LANDSCAPE AND VISUAL REVIEW
OF THE DEVELOPMENT CONSENT ORDER (DCO) APPLICATION
FOR THE SPRINGWELL SOLAR PROJECT
FOR
LINCOLNSHIRE COUNTY COUNCIL
&
NORTH KESTIVEN DISTRICT COUNCIL

May 2025

Landscape and Visual Review

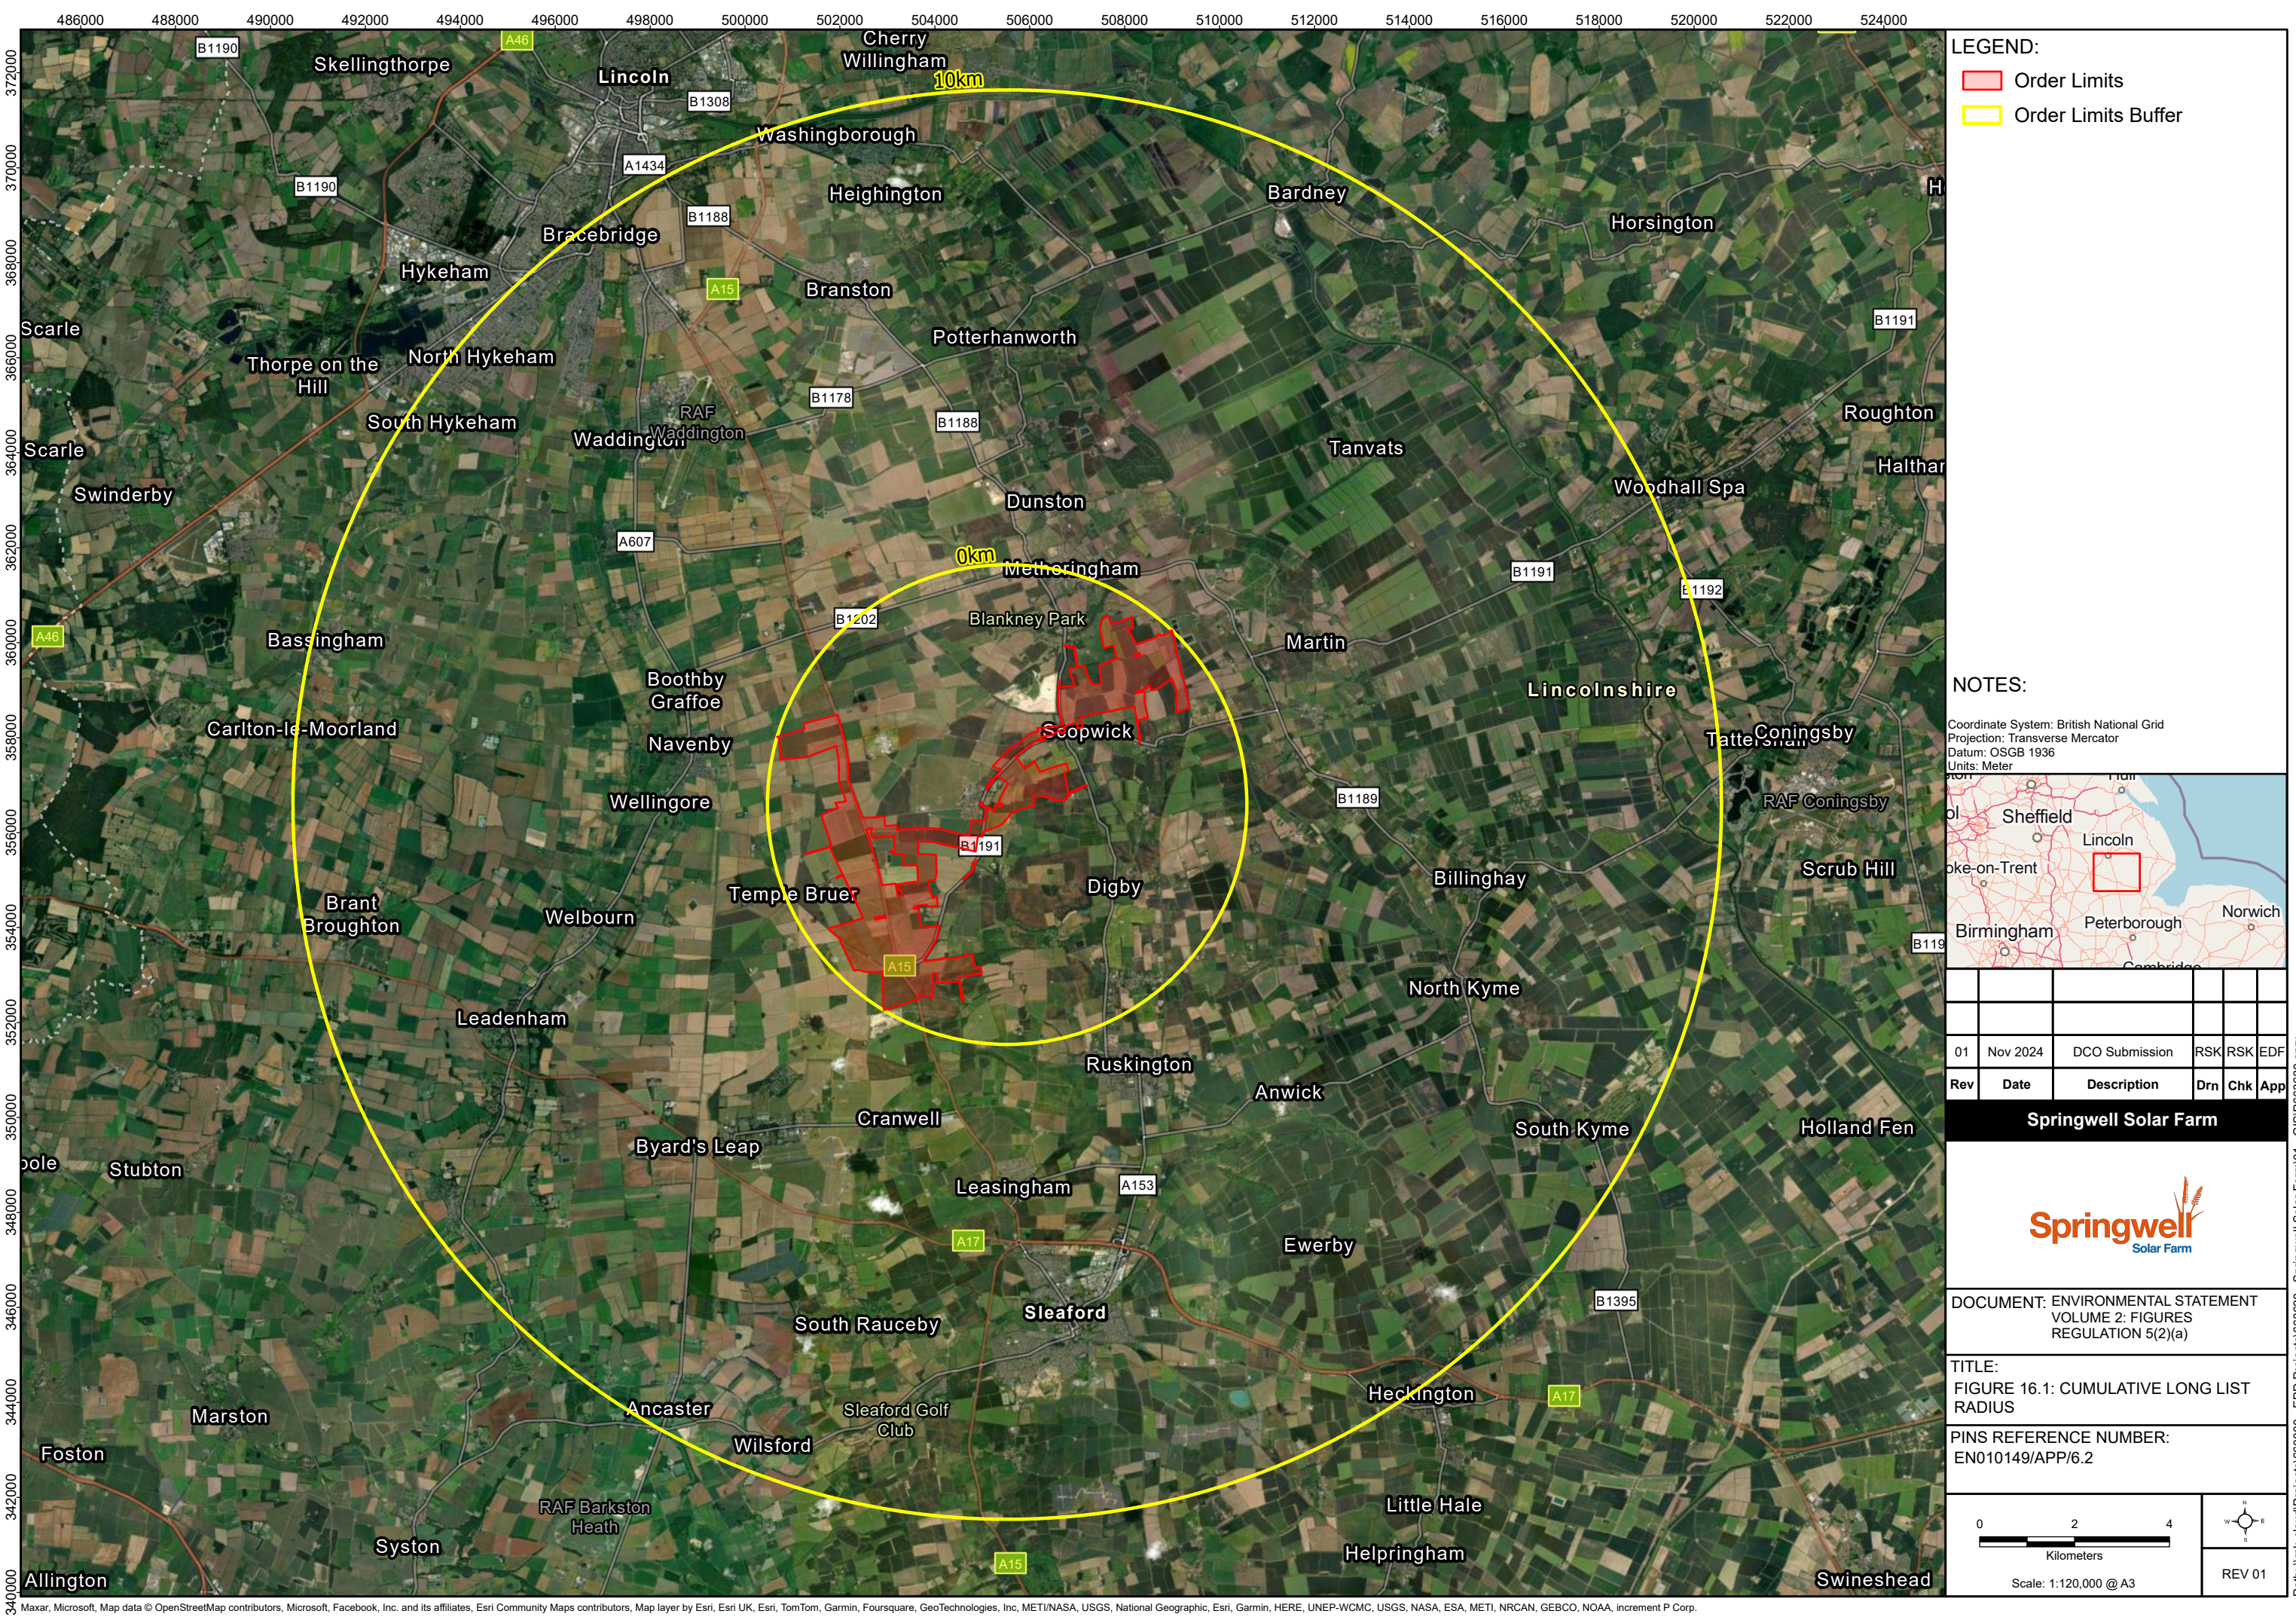
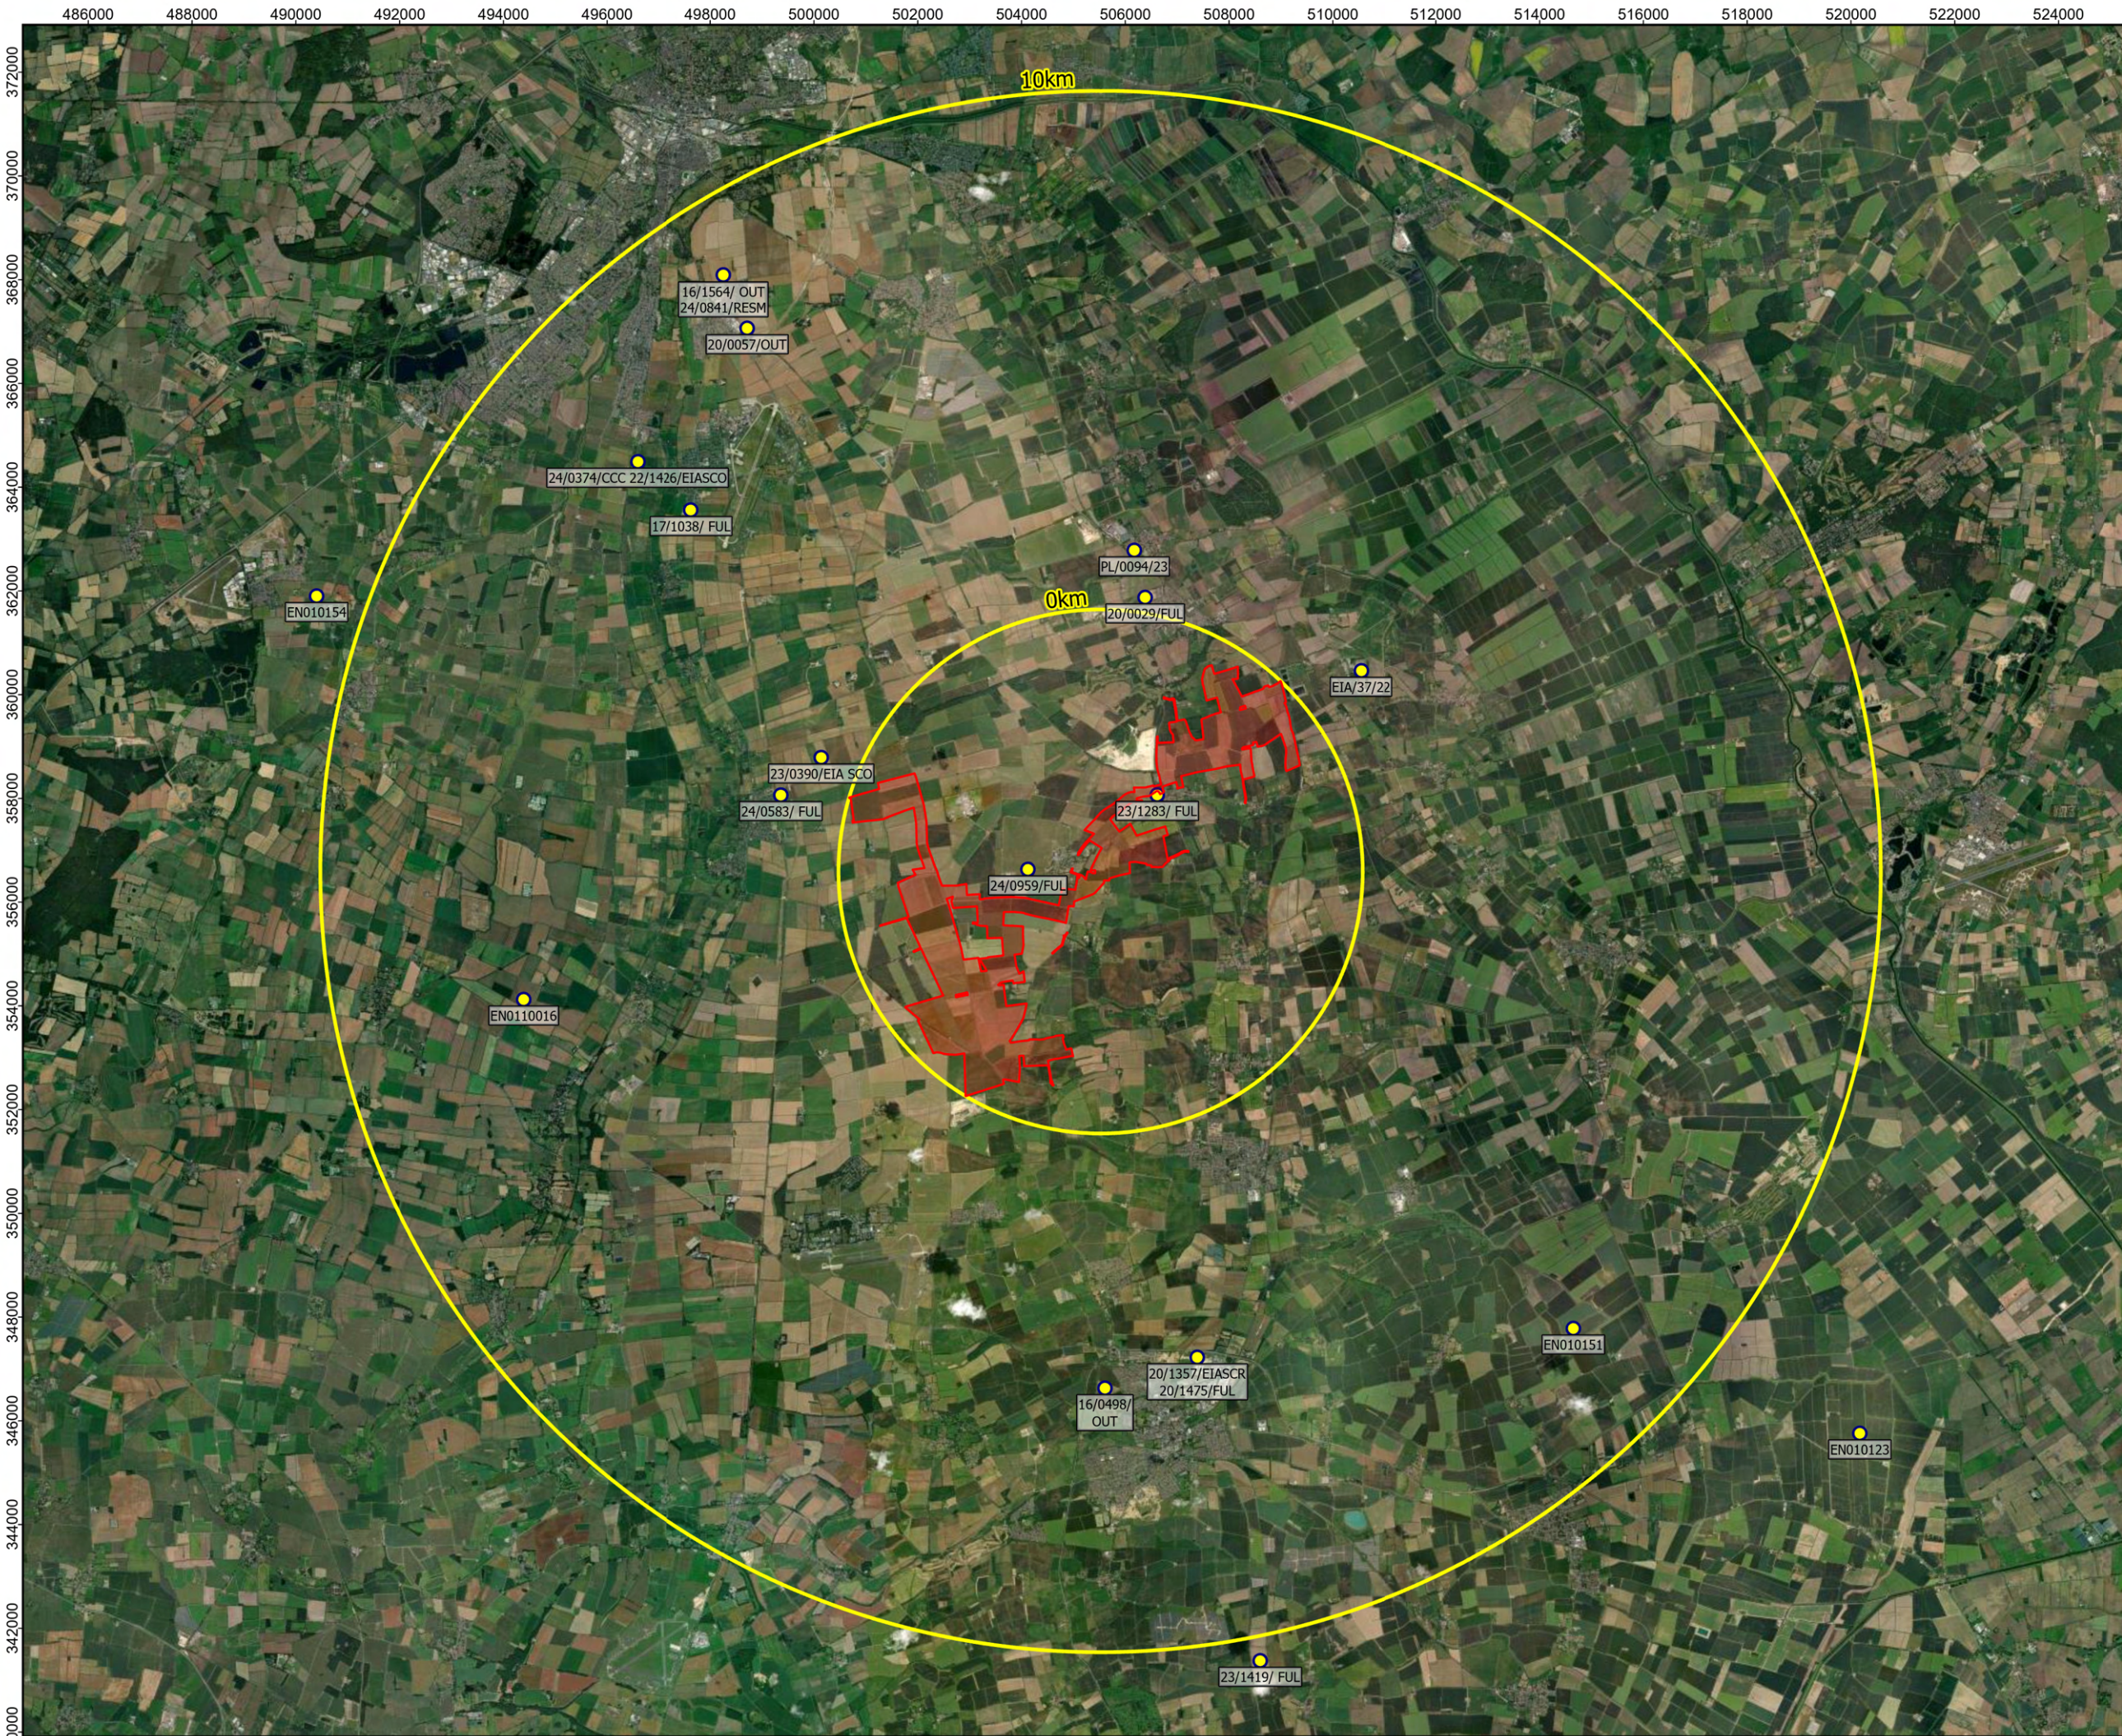
- 6.7 Leoda Solar Farm, to the west of Springwell Solar should also be considered in wider landscape and visual effects. While it is unlikely this scheme would be seen in the same view as Springwell, the change in land use in the wider landscape, along with potential for sequential views, particularly when considering travelling east to west with sequential views of Springwell, Leoda and Fosse Green possible along linear routes.
